re: Noise Impact Assessment - Response to City Comments
Proposed Multi-Storey Residential Building
817 Roseview Avenue - Ottawa

date: March 24, 2022

file: PG5898-MEMO.01

Title: **RECEPTOR LOCATION PLAN**

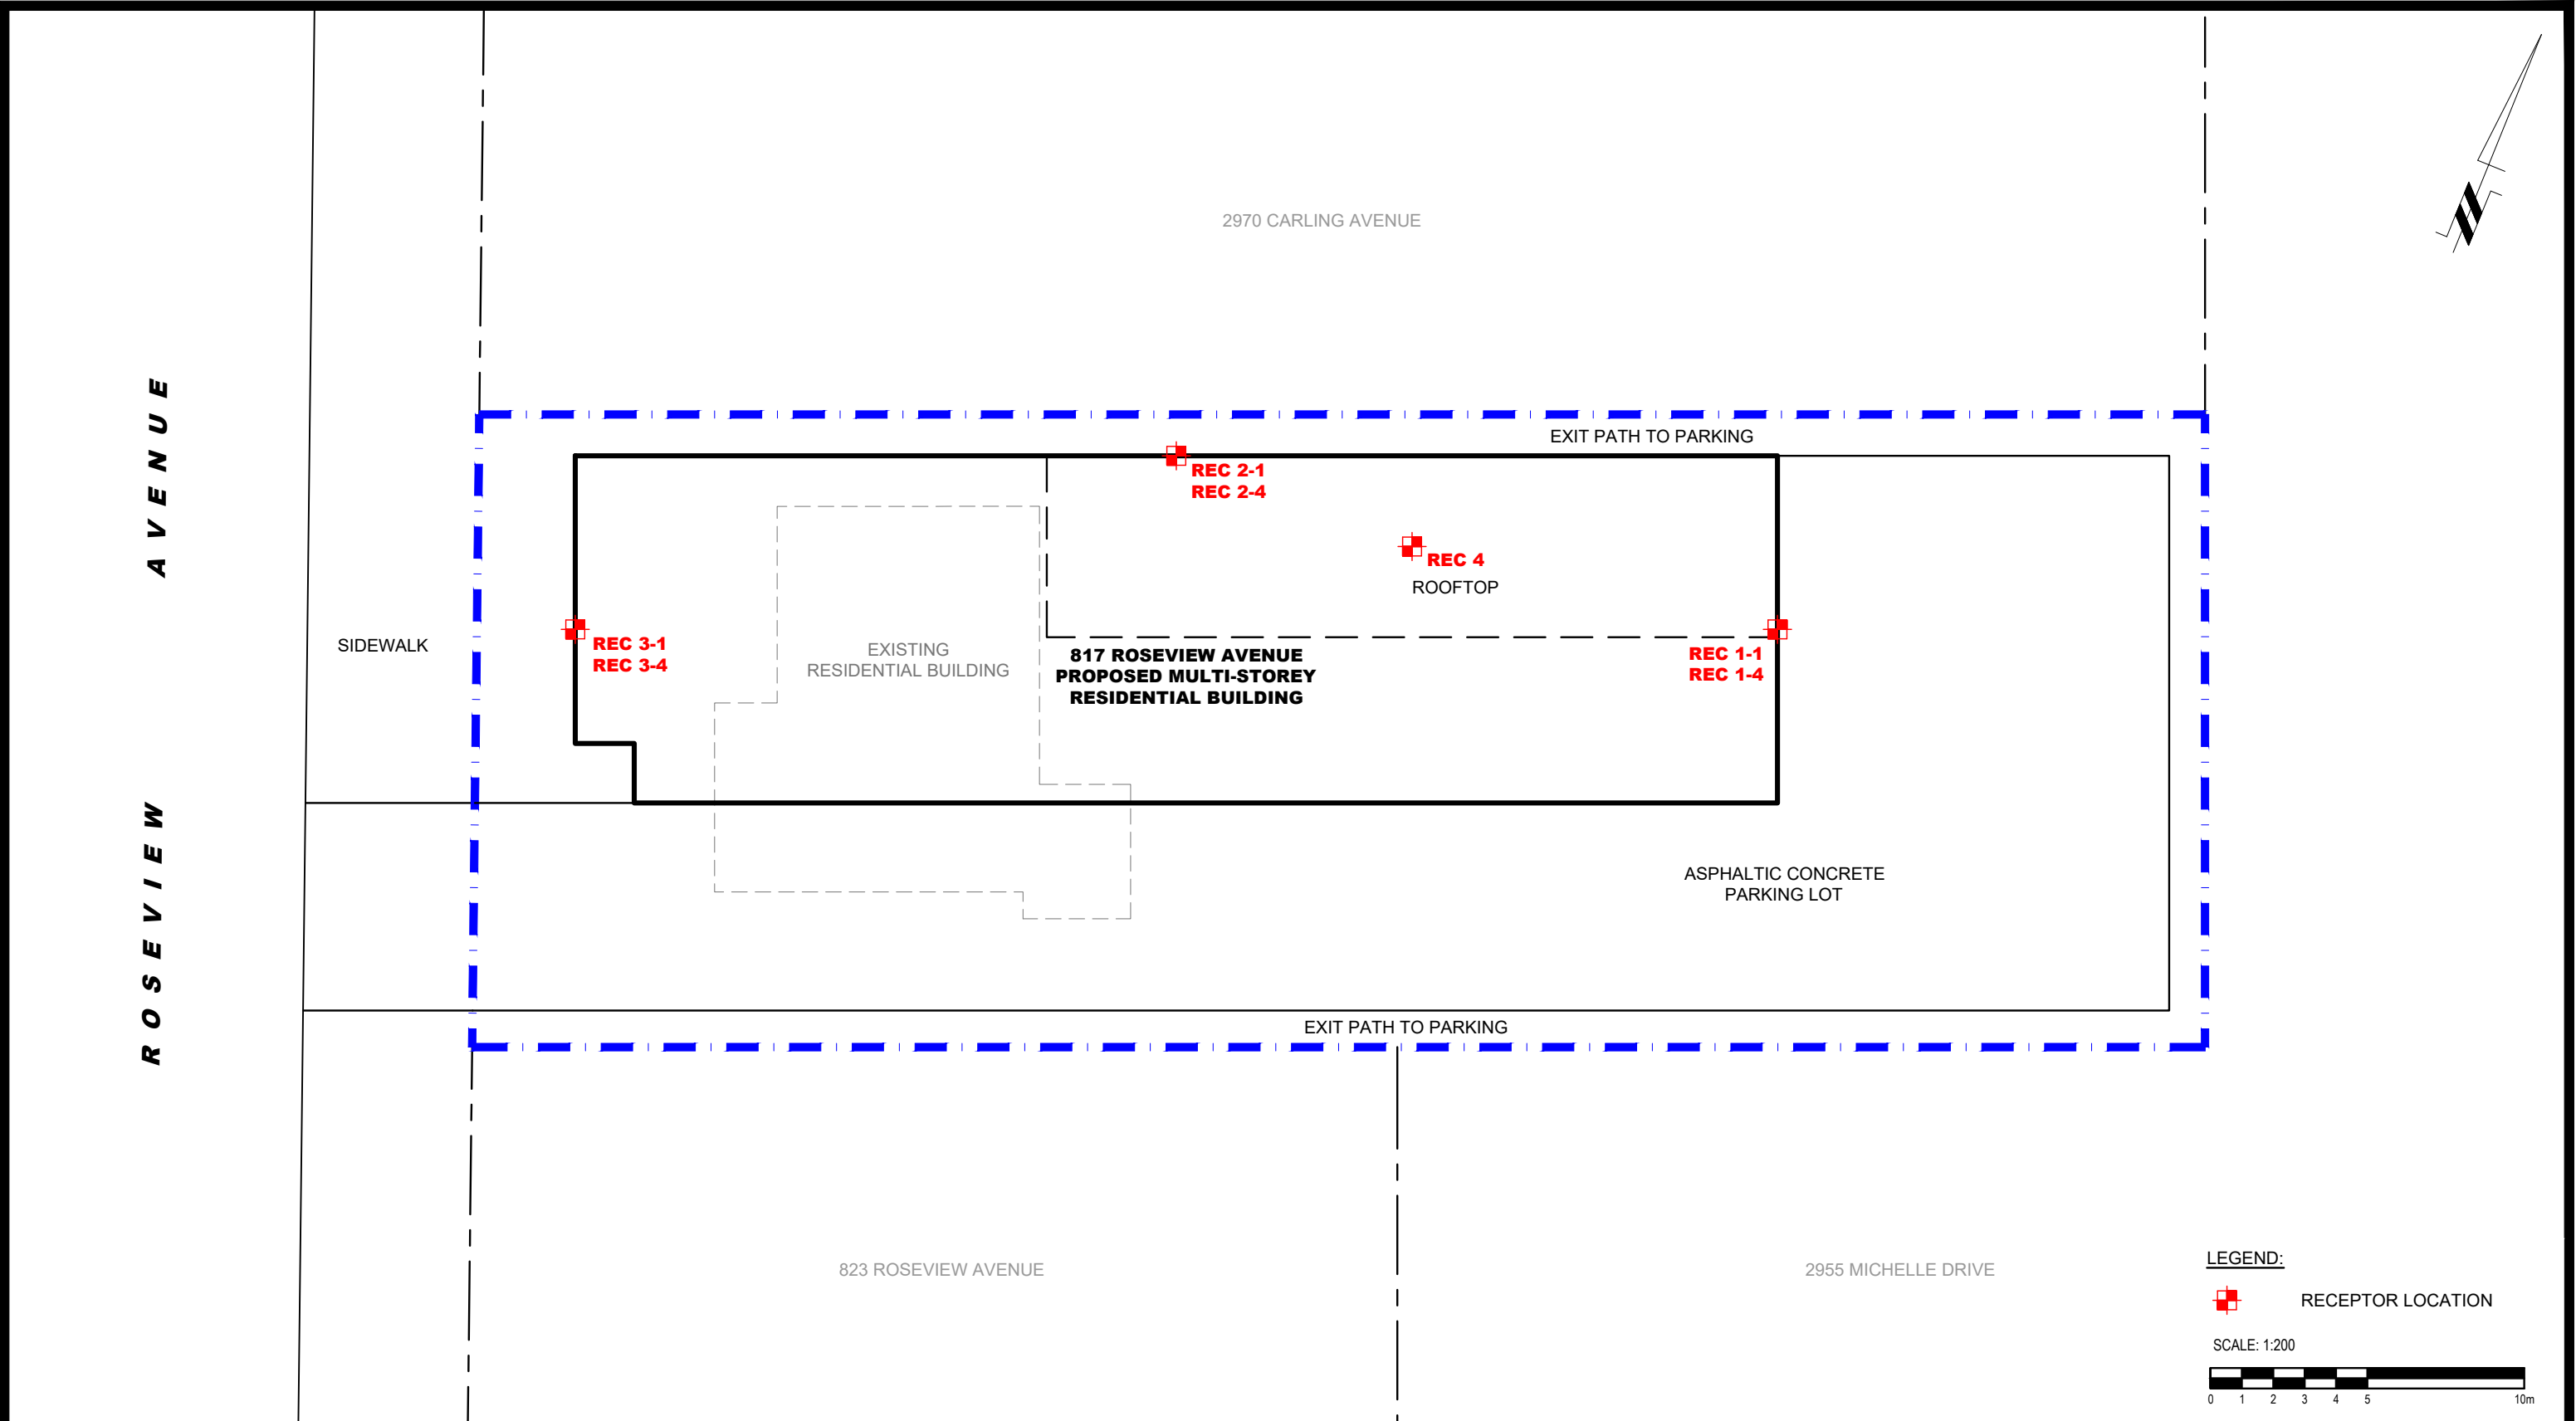
Comment 1: 2.3. *While a noise reduction railing on the rooftop area will make the inclusion of a clause permissible, the applicant is encouraged to consider further measures to reduce the noise to below 55 dBA in order to make this space as attractive to use as possible.*

Based on our correspondences with Mr. Fernando Matos, it is understood that the conceptual plan of the proposed building has been revised. It is noted that the proposed rooftop amenity area has also been revised.

A surface transportation noise analysis has been done at the rooftop amenity area. The result of STAMSON modeling indicate that the noise levels at the rooftop amenity area during the daytime period is expected to be 61 dBA, which exceeds the 55 dBA threshold value specified by ENCG. According to ENCG, noise control measures (i.e. barriers) are required to reduce the L_{eq} to 55 dBA where technically and economically feasible. An investigation including noise barriers, which included both the exterior cladding of the proposed building in addition to the installation of a 1 m solid railing around the perimeter of rooftop amenity area found that the noise levels can be reduce to 58 dBA, but cannot be reduced to 55 dBA without the application of an excessively tall barrier.

It is understood that it would be much more attractive to reduce the noise levels at rooftop amenity area to below 55 dBA. However, the surface transportation noise analysis shows that it is not technically and economically feasible to further reduce the noise levels to below 55 dBA.
